Address: 300, Huddersfield Road, Huddersfield, HD8 8NE

Application number: 2026/90890	
What is the application for?:	Formation of new farm access
Address of the site or building:	Land off, Huddersfield Road, Shelley, Huddersfield, HD8 8NE
Postcode:	HD8 9AZ

Title
 PROPOSED NEW ACCESS TO
 HUDDERSFIELD ROAD

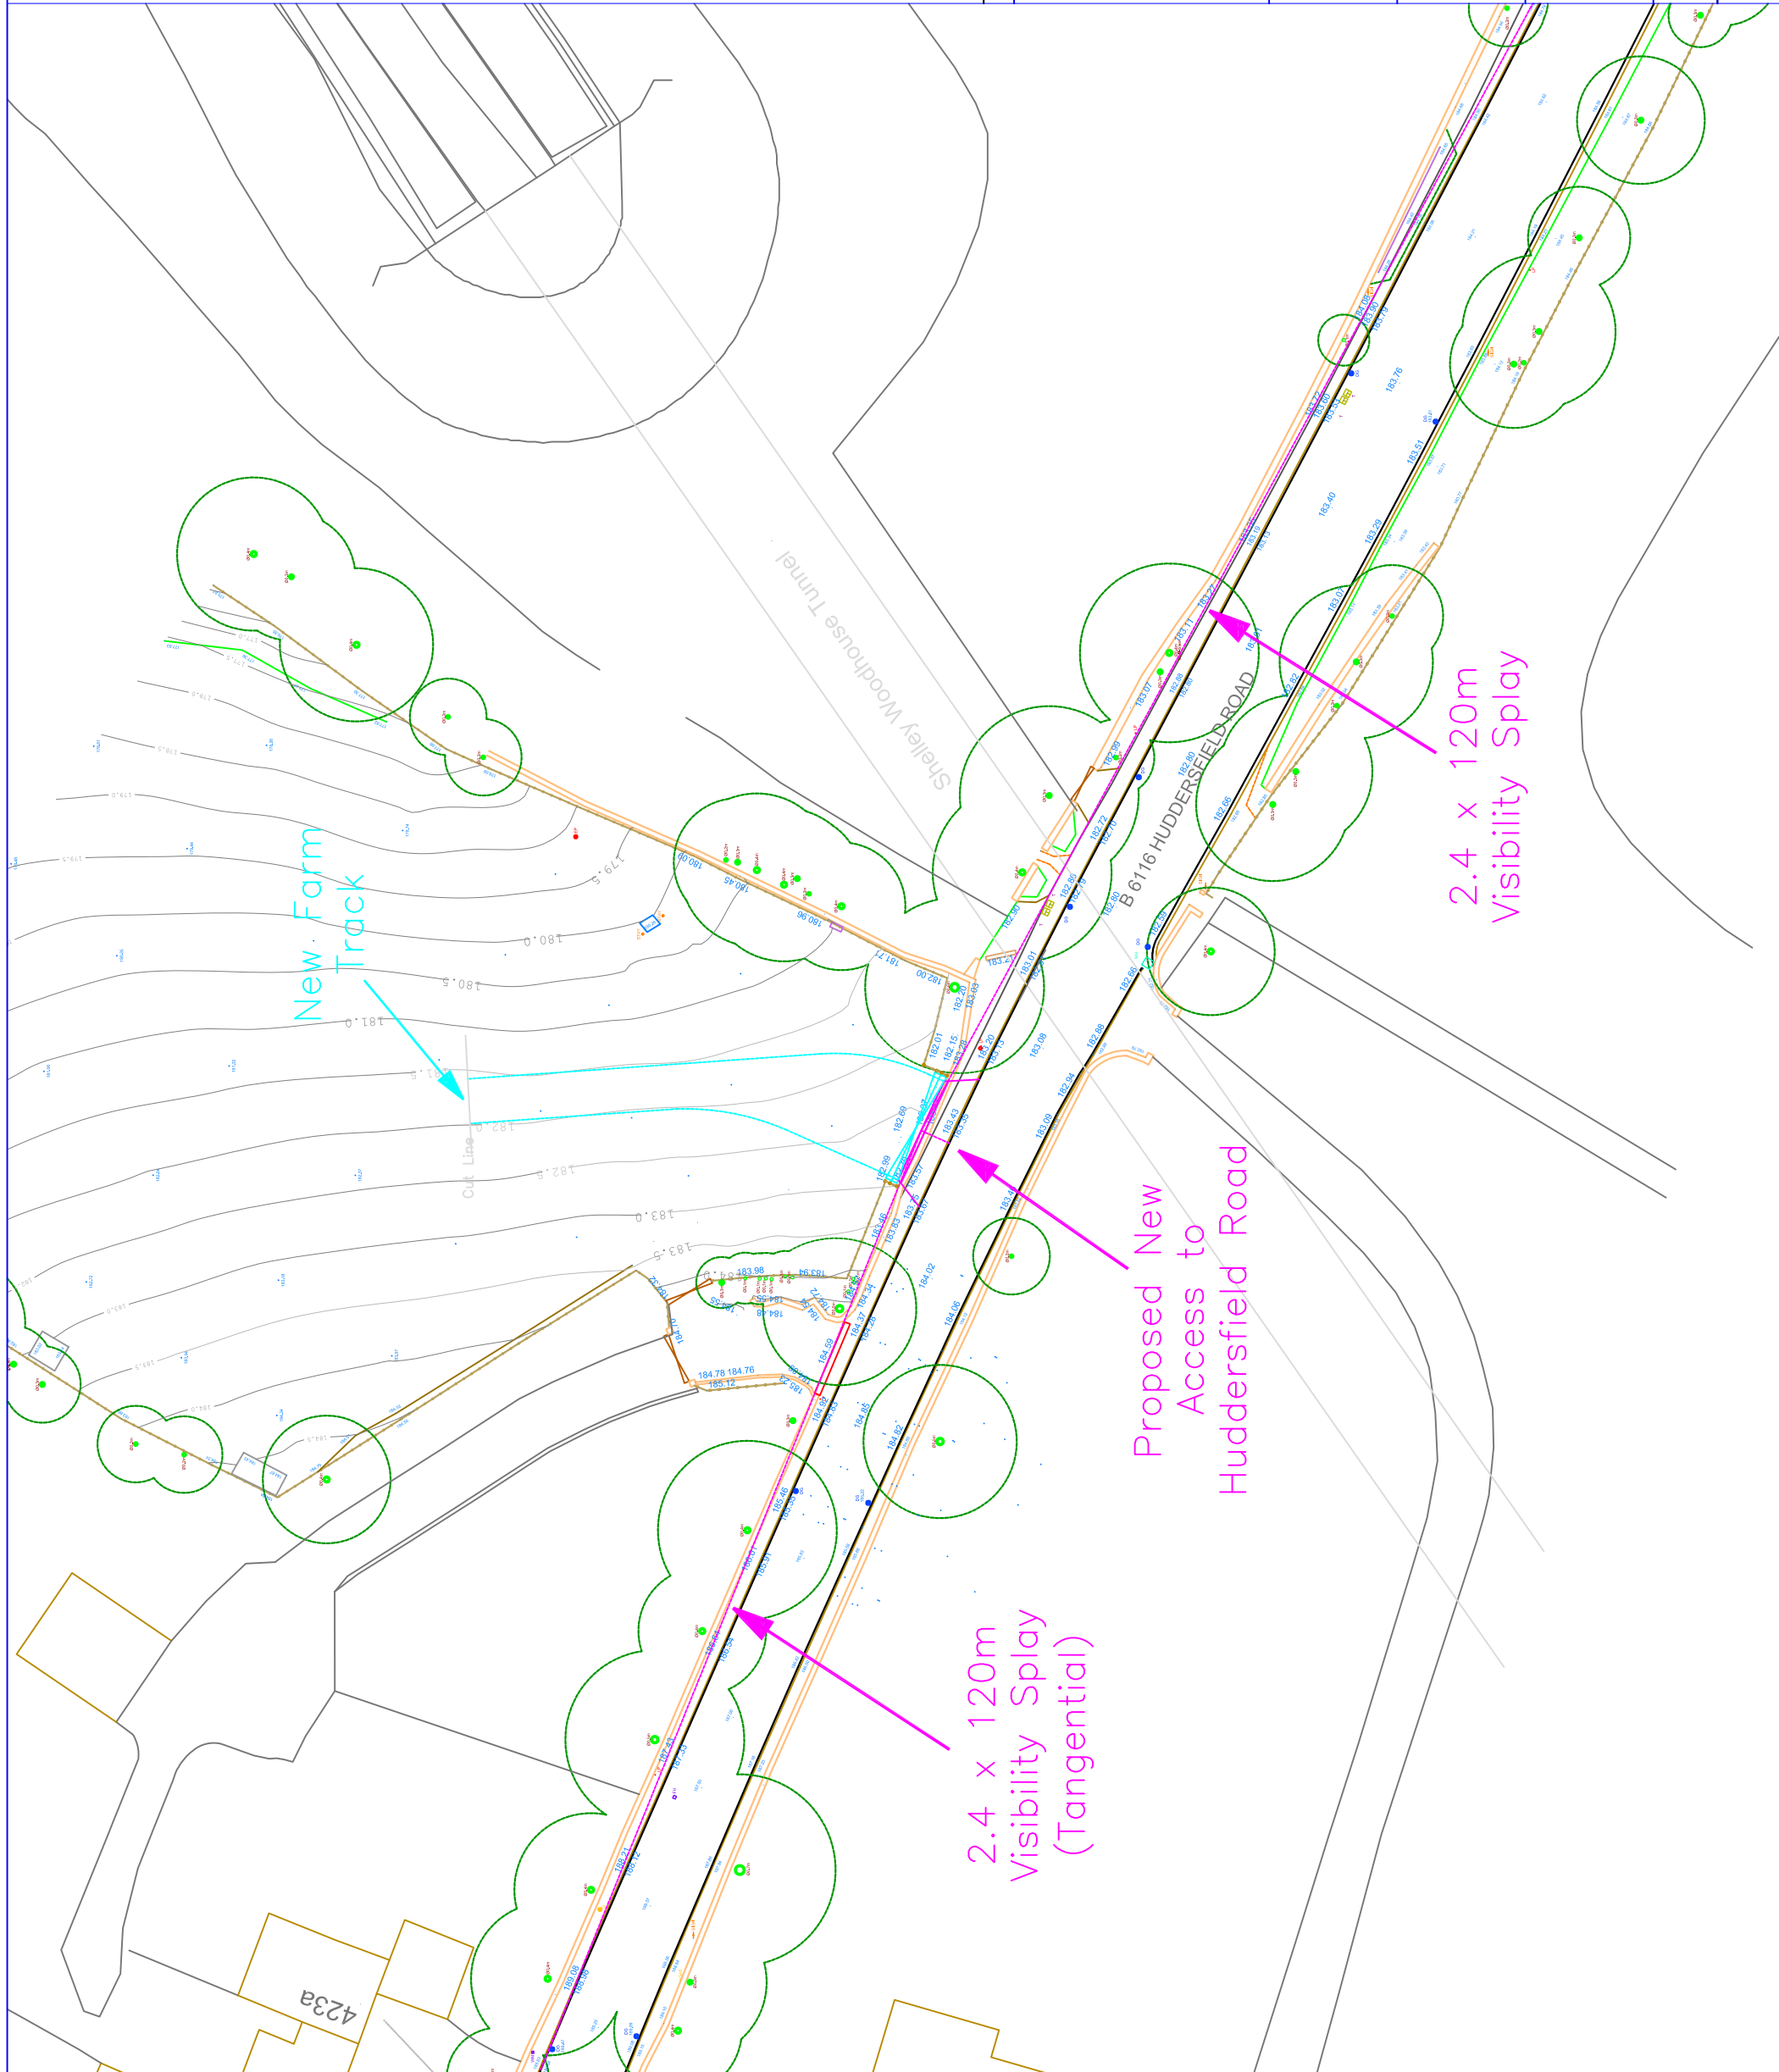
Type of comment: An objection	
Do you wish your comments to be published on the website anonymously?	No
Traffic survey was between 11 and 12 which is not a busy time. School times traffic comes to a standstill all way from school up the hill and Shelley Woodhouse Lane morning and afternoon. During the day often traffic backs up down the hill when unable to pass buses at the bus stop further up road. It will be dangerous with farm machinery turning into the proposed gateway.
